27th May 2020

Application No: AL/34/20/PL
Site Address: Norton Farm House Norton Lane Aldingbourne PO20 3NH
Description of works: Sub-division of existing building to create 1 NO. 1- bed dwelling & construction of 4 bay oak framed outbuilding as a garage. This application affects the character & appearance of the Norton Lane, Norton Conservation Area & affects the setting of a Listed Building.

Thank you for your internet representation made on 26th May 2020 which has been recorded as an objection with the comments as follows:

LOCATION PLAN AND BLOCK PLAN

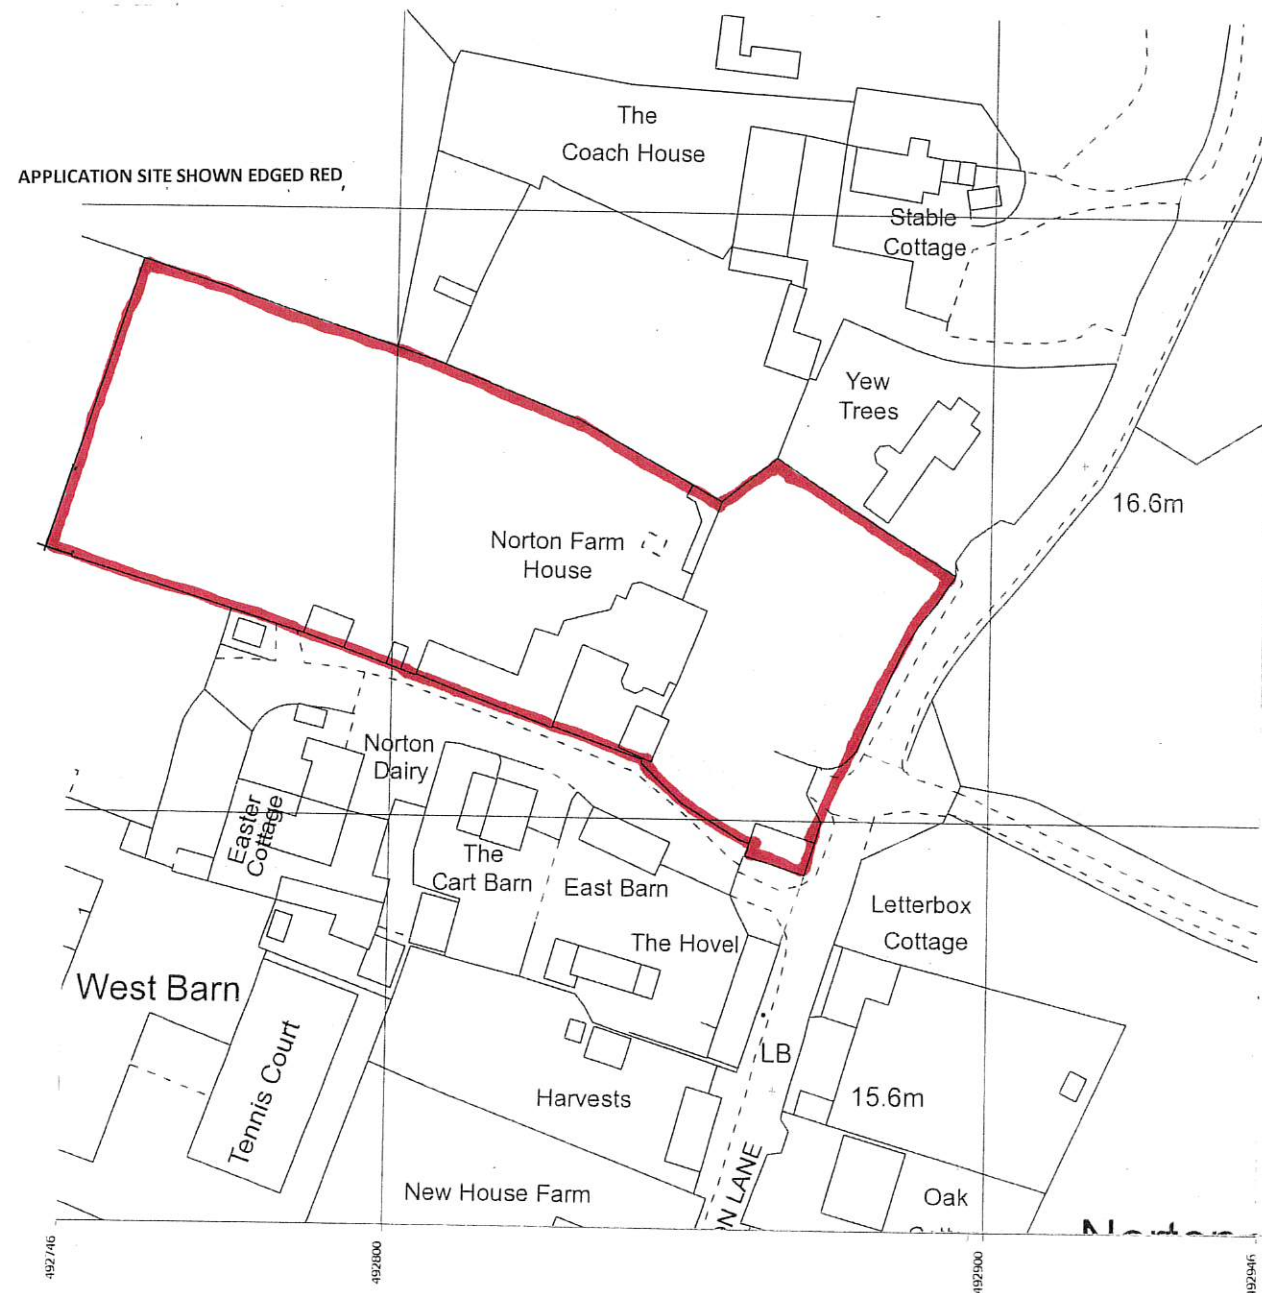
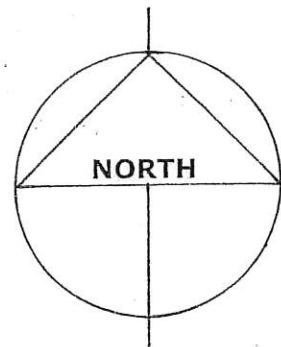
I would like to object to this planning application under grounds that the red line around the location plan/site plan incorporates part of my title/ownership (please advise if you need my Land Registry Plan? No notice has been served on me so may ask the Council to carry out the necessary procedures?

It would appear that the red line incorporates another title which is agricultural land.

The Location and Block Plan show a building that would have to be demolished to allow for the carport which I understand would be listed too as it falls within the curtilage of a listed building.

Where is the vehicular access to the proposed carport as I understand these plans should show?
